**Re: Re-submission of details to discharge Condition 10, 11, 12 & 16 of planning permission AL/20/21/PL**

This covering letter accompanies the application and supporting documents submitted online through the Planning Portal under the reference: PP-11225709, which relates to the re-submission of details to support the discharge of Condition 10, 11, 12 & 16 of planning permission AL/20/21/PL at Land at Wings Nursery, Lidsey Road, Woodgate, PO20 3SU.

Engineers Comments Regarding Condition 10

ATTENUATION BASIN
POND SECTIONS
(1:100)

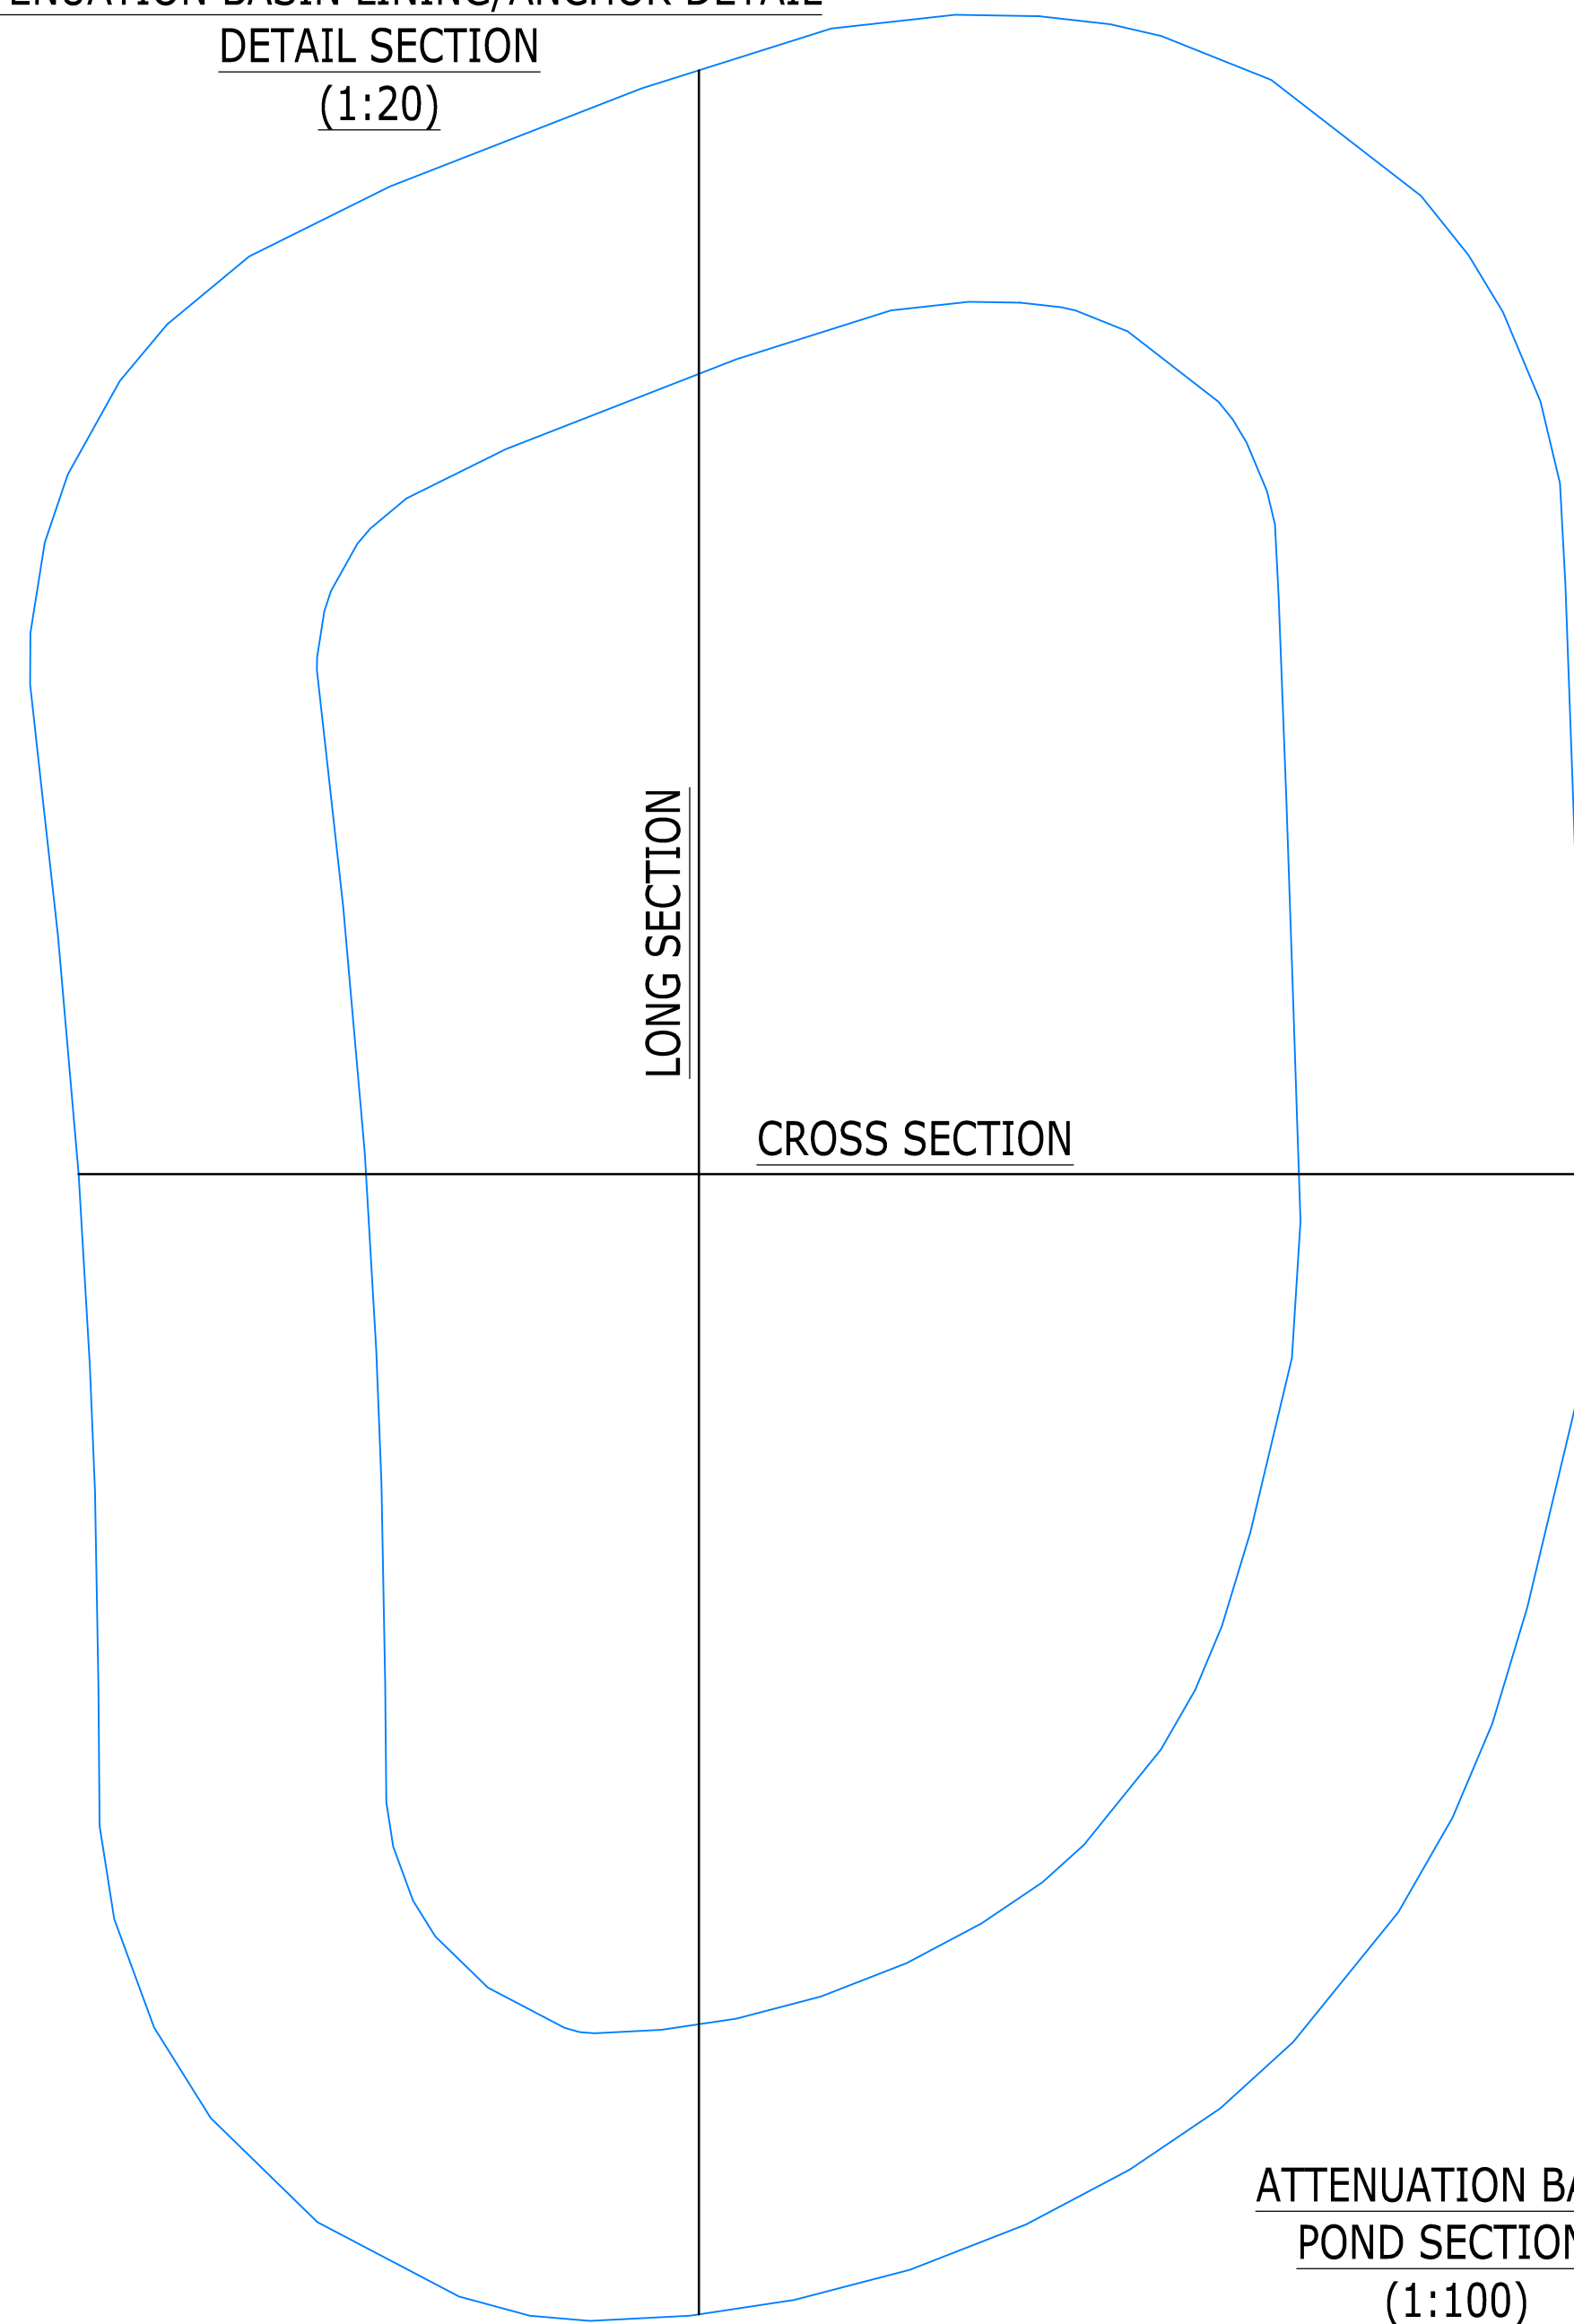
12. Please provide flotation calculations for cellular storage and attenuation basin. *Calculations provided, however no groundwater data near basin. Assumed depth of groundwater requires discussion and agreement.*

16. Please provide construction detail drawings of permeable paving. *Okay.*
17. Please provide two perpendicular cross sections of the basin, please detail liner, topsoil depths, etc. on construction detail drawing. *See comment 12.*

Point 12 - The depth of groundwater in vicinity of the pond, noting the final peak winter groundwater monitoring is 0mm BGL for the flotation calculations. The proposed pond rim is approximately 250mm above natural ground level at this location, so the spreadsheet inputs currently reflect this. The calculation also includes for a 1.2 safety factor.

Point 17 – Drawing provided.

FLOW CONTROL CHAMBER S102
(Scale 1:20)

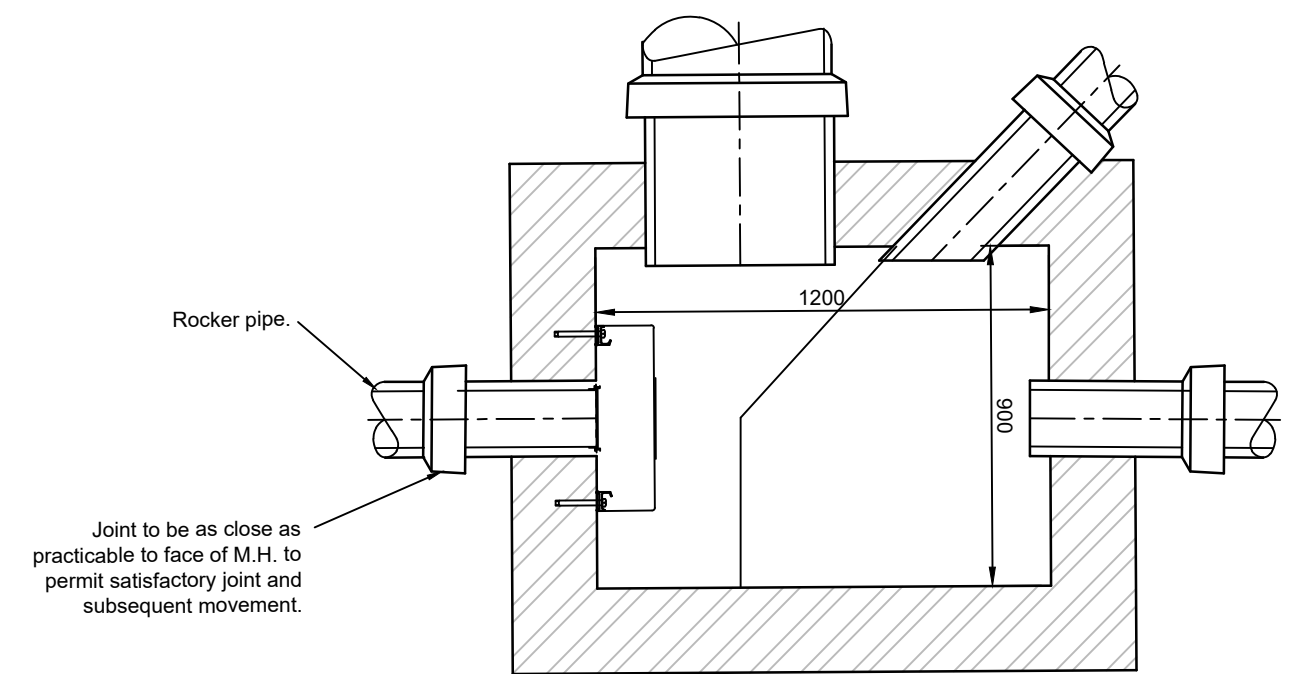
13. Please provide data sheets to evidence flow control devices for S102 and S23 will achieve the criteria within the flow model. *Provided, however please see points 2 and 3 which will alter this.*

Point 13 – Points 2 and 3 resolve point 13
